Re: The Barn Hotel 7969/APP/2024/2451 - Waste comments

From: Romy Santer <RSanter@hillingdon.gov.uk>
Sent: 18 June 2026 08:21
To: Dimitra Angelopoulou <DAngelopoulou@hillingdon.gov.uk>
Subject: Re: The Barn Hotel 7969/APP/2024/2451 - Waste comments

DETAILS Cycle & Refuse Stores

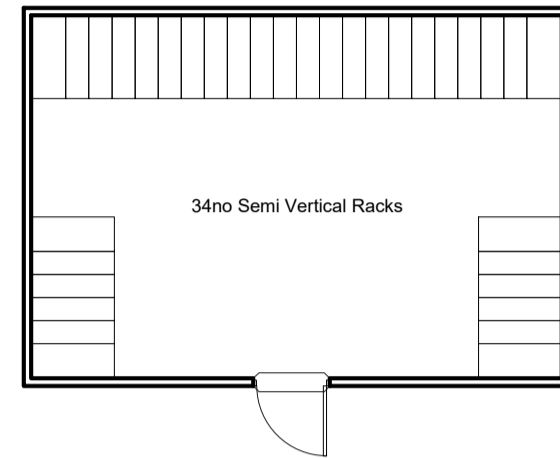
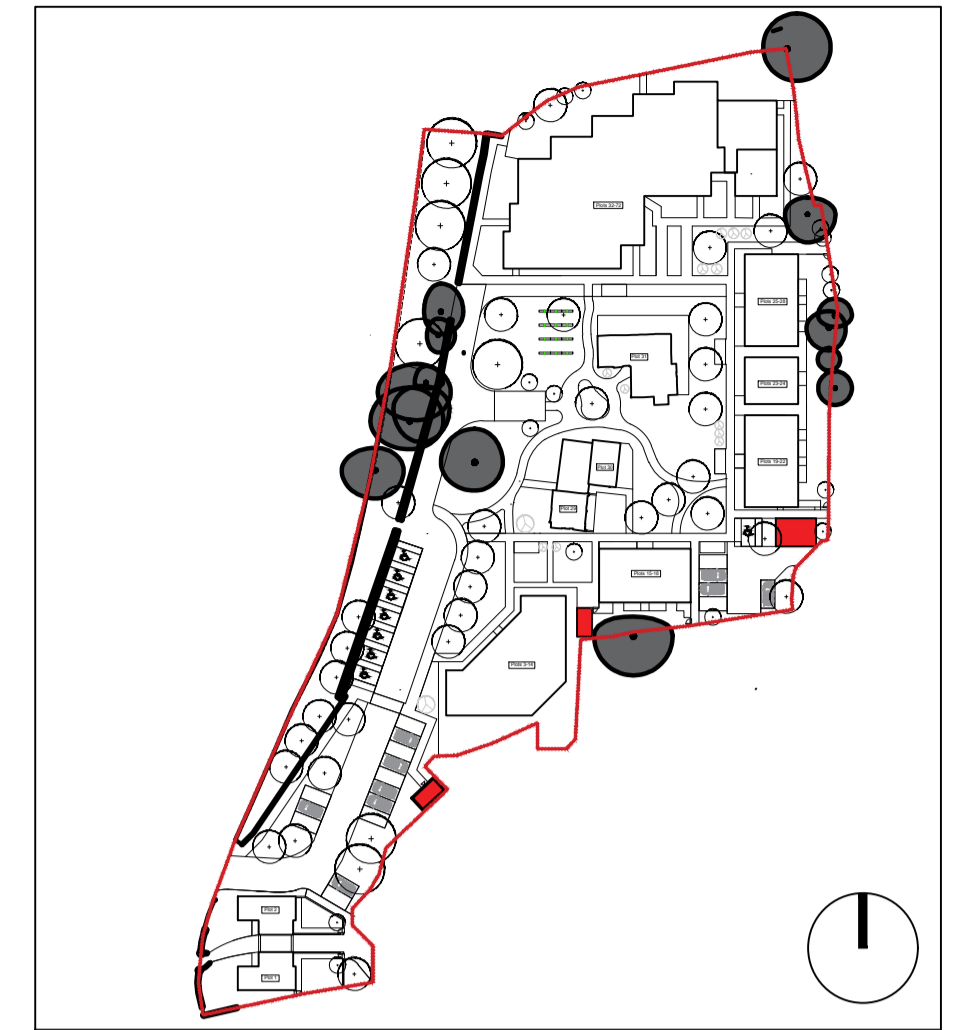
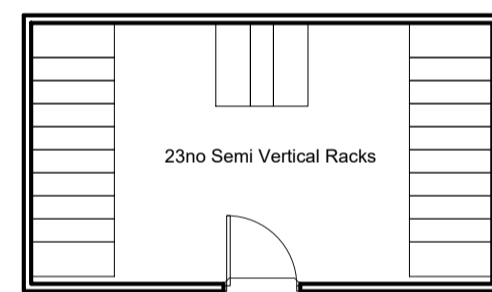
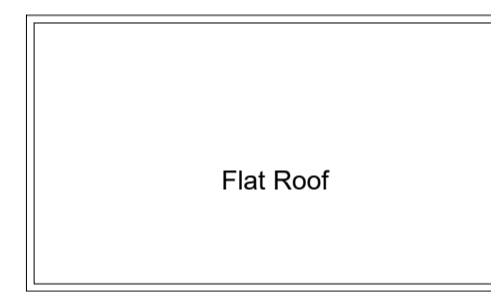
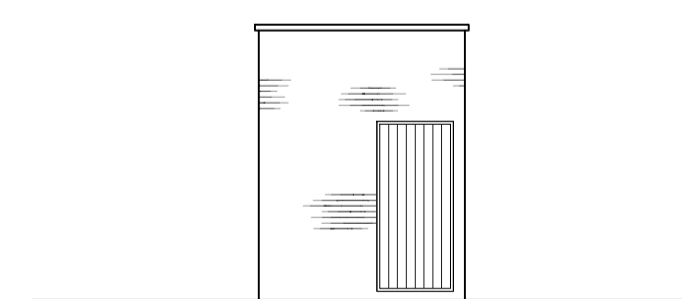
- For A, D-G: we do have the ability to collect 240L bins as we are a sack only collection borough. Instead I would suggest either these residents use 80L dust bins that our crews can empty or they present sacks on the kerbside for collection. Happy to discuss further. **We are showing space for 2 x 240L bins for each house so this should therefore be plenty of space for the dust sacks.**

- For B- the bins should be 1100L not 240L. Capacity is calculated at 120L per room (60L for general and 60L for recycling): I would go with 2x 1100L refuse and 2 x 1100 recycling and 1 x 140L food waste. **Apologies, there is an error on the label. The drawing does actually show 6 x 1100L + 2 x 240L bins (so more than enough) but the label is incorrect. Corrected version attached.**

- For K- I would go with 3 x 1100L general waste, 3 x 1100L recycling and 2 x 140L food waste. **Again, the label missed off the smaller bins, updated drawing now showing 7 x 1100L + 2 x 240L, so more than enough.**

All bins should have space to move around. Each type of waste such as general, their bins should be able to be removed from the bin store without moving bins from any other service. Ensure there is space in the bin store for extra bins to future proof for service changes. **There is at least 2m of manoeuvring space in the bin stores so plenty as well as being an over allowance.**

Figure 6.1: Waste Storage & Collection

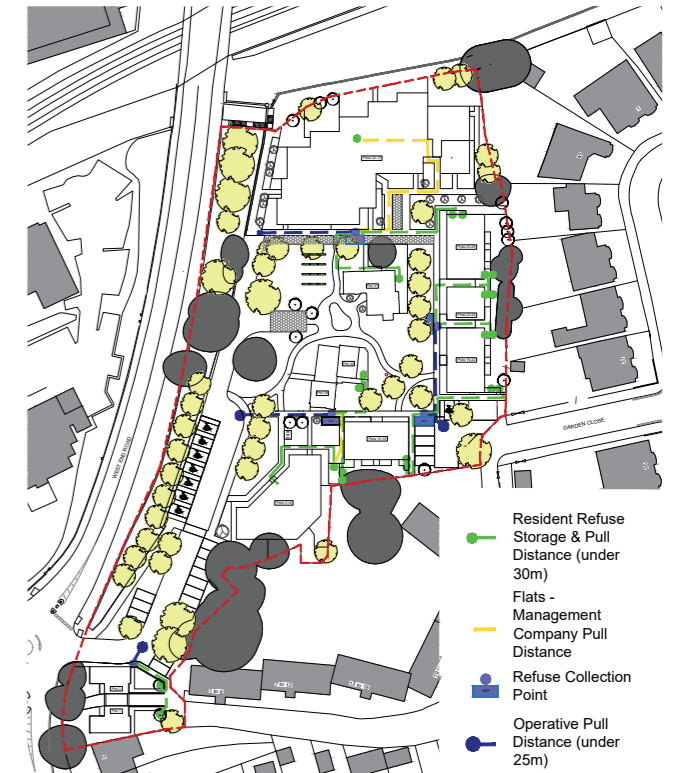
- The Design Access Statement mentions a "Refuse Management & Servicing Plan"; I cannot find this in the documentation.
- Due to not being able to find this statement, I cannot accurately comment on whether this plan should be rejected or accepted.
- A few points I can make from what I do see:
 - o Fine for residents or MA to bring waste to collection points for collection day, but if any bins are not presented for collection, we won't be able to come back until the next collection day so it will be up to you to resolve.
 - o Operative pull distance from collection point to vehicle needs to be less than 10m not 25m. I would need a close up of Figure 6.1 from the Design Access Statement to see this in more detail.
 - o I cannot see how big the bin stores are, how big the collection points are or the services for refuse, food waste and dry mixed recycling.
